Engineers Comments Regarding Condition 5- Surface Water Drainage

ADC comments 15/09/20

WSP Reply 12/10/20

ADC Further comments 13/10/20

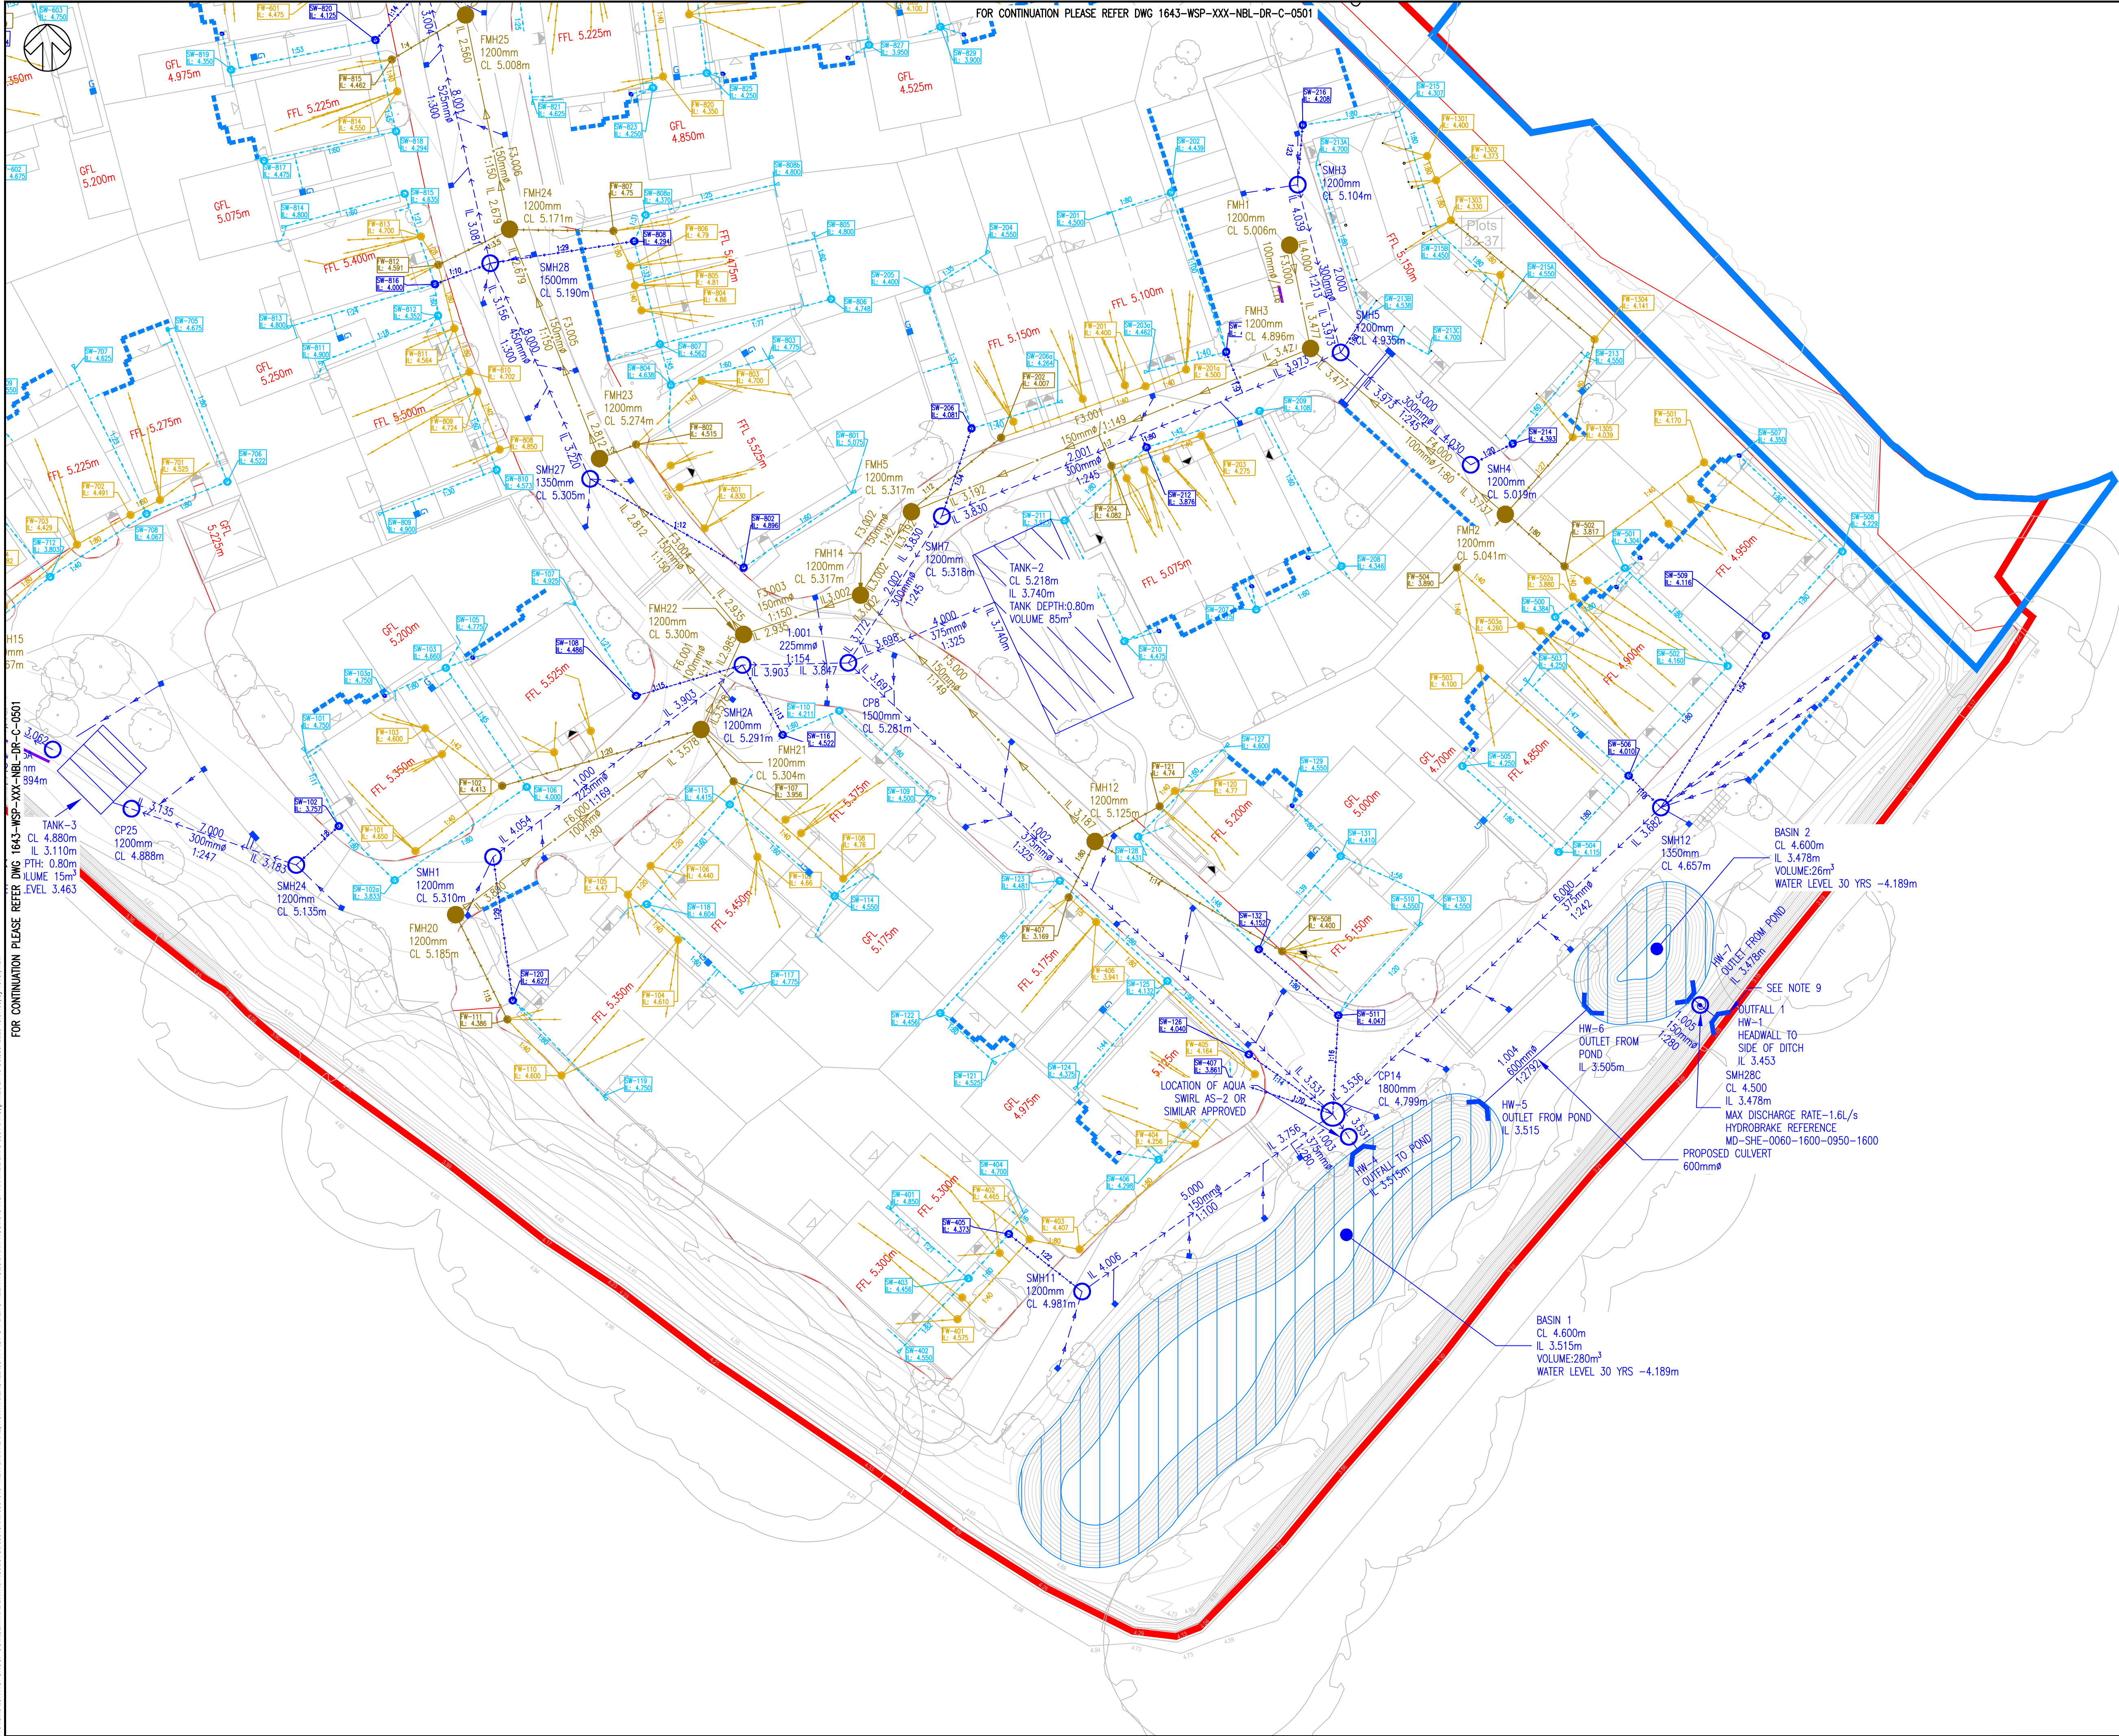
- a. As shown by layout drawings 1643-WSP-XXX-NBL-DR-C-0501 and 0502. We have set the levels of the outfalls above the nearby culverts into which the ditches discharge. *Further information required. Not clear on current plans. Minimum of 150mm between ditch bed and invert level of outfalls required.* Drawing 1643-WSP-XXX-NBL-DR-C-0520 displays the level of the outfalls, all of which are above the lowest surveyed point of the receiving ditches. Although the levels are not 150mm above the lowest surveyed ditch level (which we assume was the water level /lowest safe level the surveyors could get to on the day), the ditch bed level will be lower than this. In addition, the outfalls from the ditches through the northern and southern culverts are at 2.48mAOD (north for outfalls 2 and 3) and 3.31m (south for outfall 1) respectively which are lower than our proposed headwalls.

| DRAWING No: | 1643-WSP-XXX-NBL-DR-C-0516 | REV: | P05 |

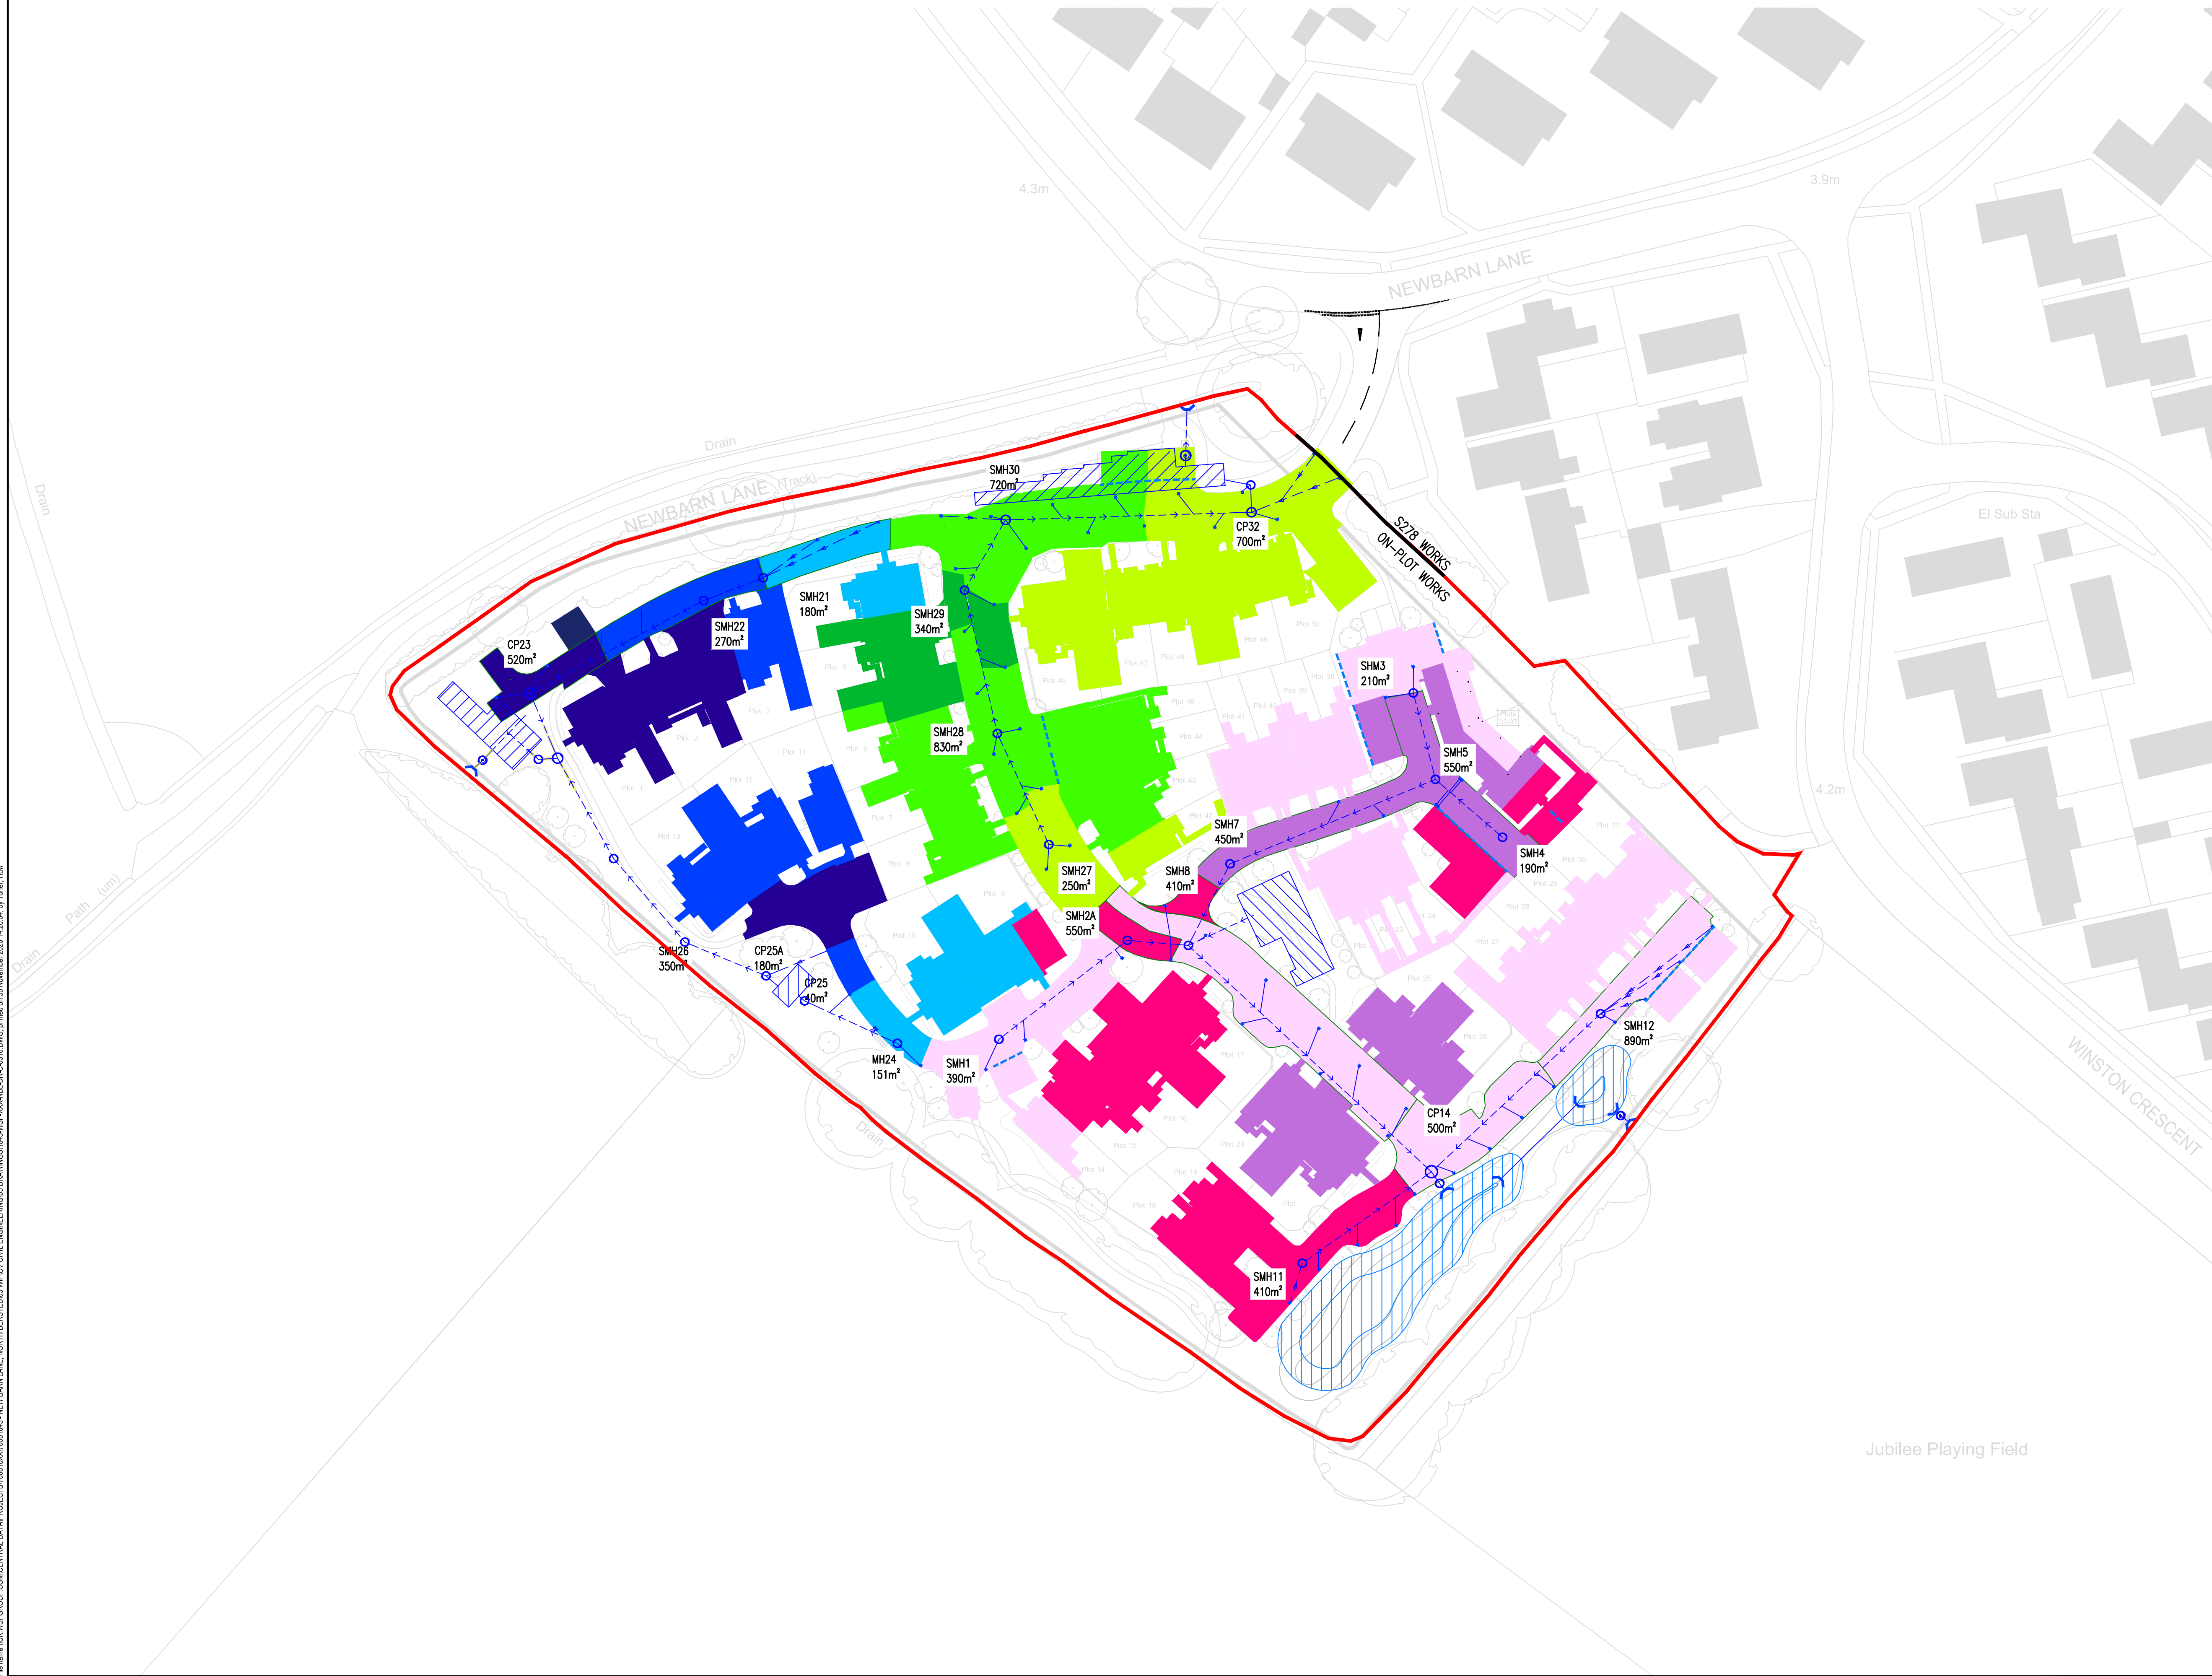
- a. As shown in Microdrainage model
 - b. Refer to drawing 1643-WSP-XXX-NBL-DR-C-0516 *okay.*
5. The proposed discharge rates are very low in some locations. A minimum permissible discharge rate of 2l/s is usually applied across the district because of the increased risk of blockage at lower flows. Please detail proposed aperture sizes so that this can be further reviewed.

| 1643-WSP-XXX-NBL-DR-C-0518   |           |                   | P05          |

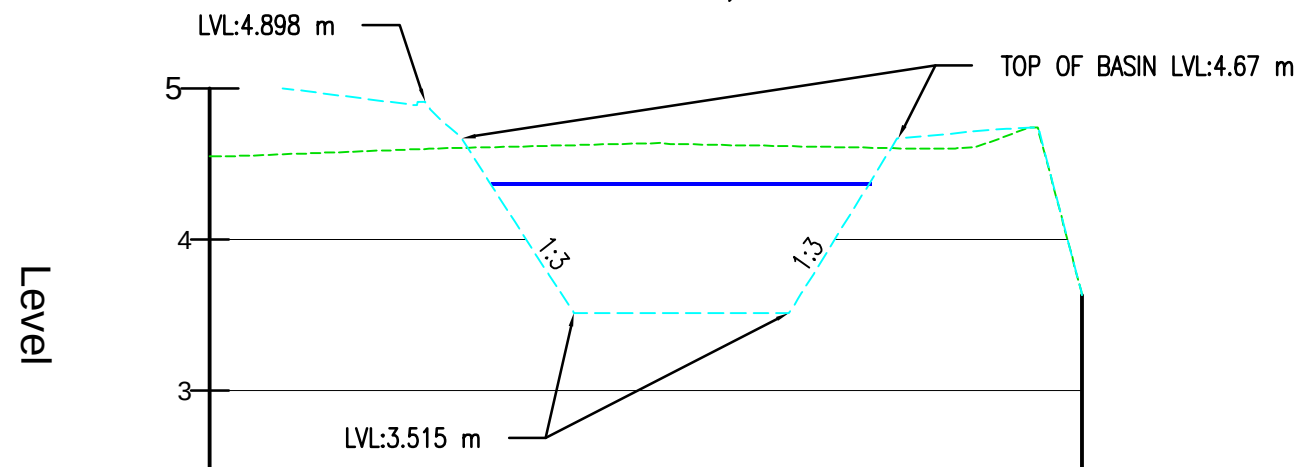
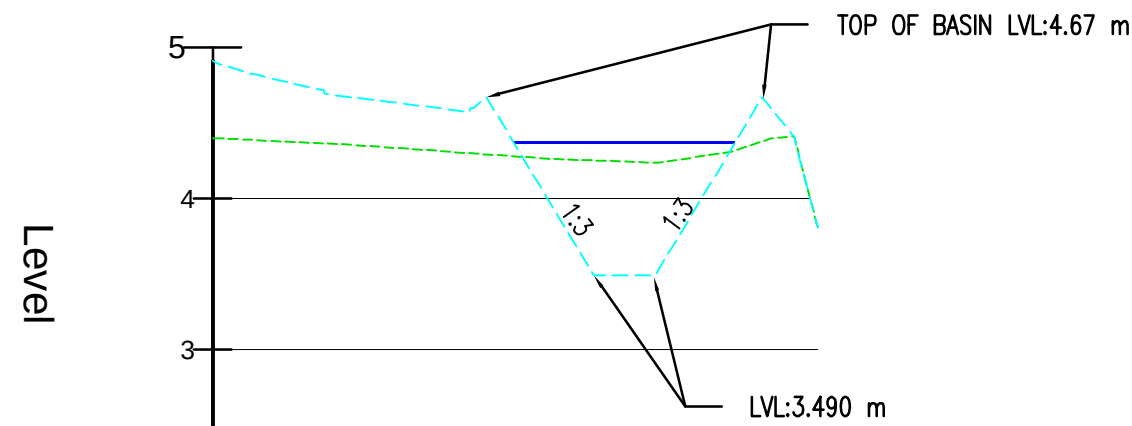
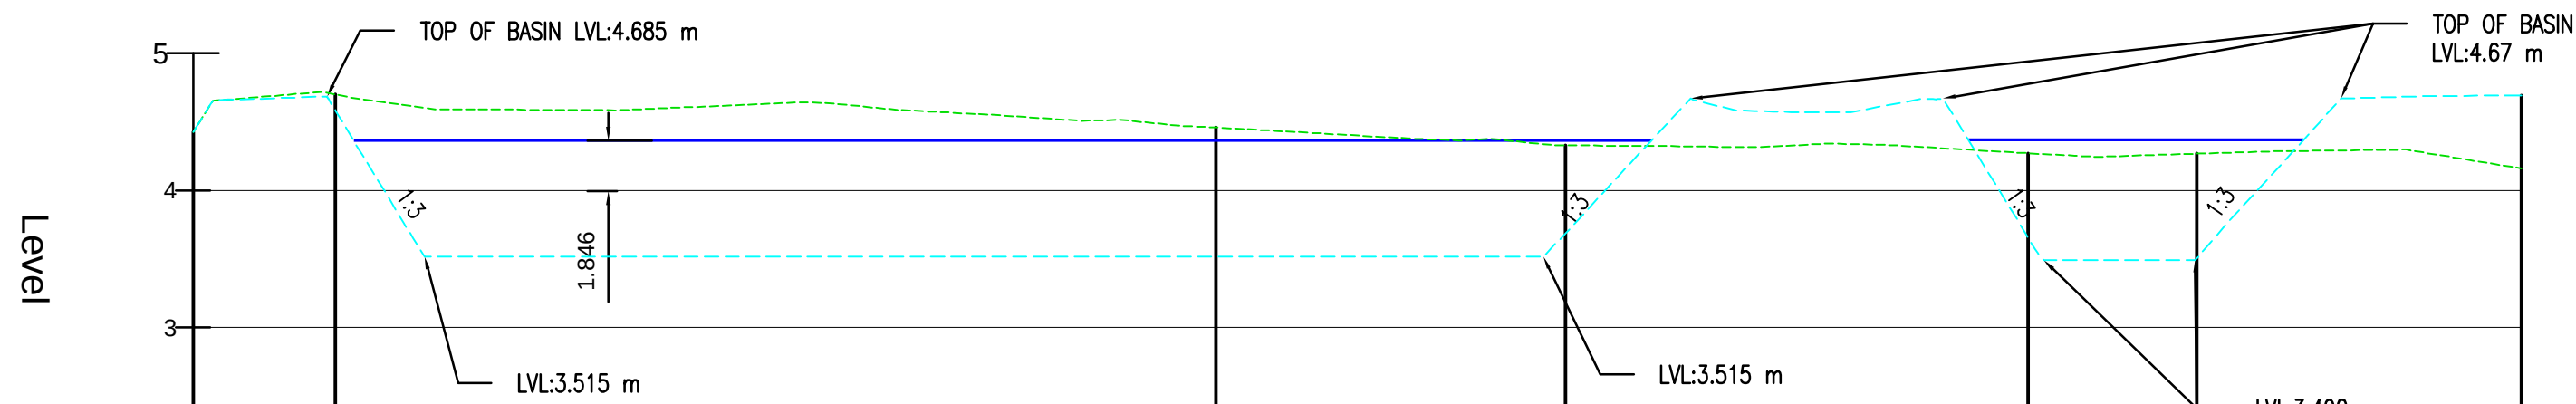
- a. As shown by section drawing 1643-WSP-XXX-NBL-DR-C-0516, construction details in 0512
 - b. Sections do not show a bank level equivalent to that in calculations or layout drawings. A minimum of 300mm freeboard must be provided to the pond, i.e. bank level all around basin must reach this minimum level.

Drawing 0518 updated and provided; please note that long sections passes through both basins.
 - c. Please provide invert levels and bank levels on these plans, i.e. provide 4 cross sections, 2 for each basin, similar to that provided on 0512.
As above

- l. *Please provide 300mm of freeboard above maximum water level in basins to top of bank.* Basin now amended to ensure 300mm of freeboard
- m. *Has the rain falling on the basins been included within calculations? No, the calculations do not include for rainfall on the basins as the time of concentration will be different. We do not believe that this affects the drainage network or philosophy of the drainage strategy.*
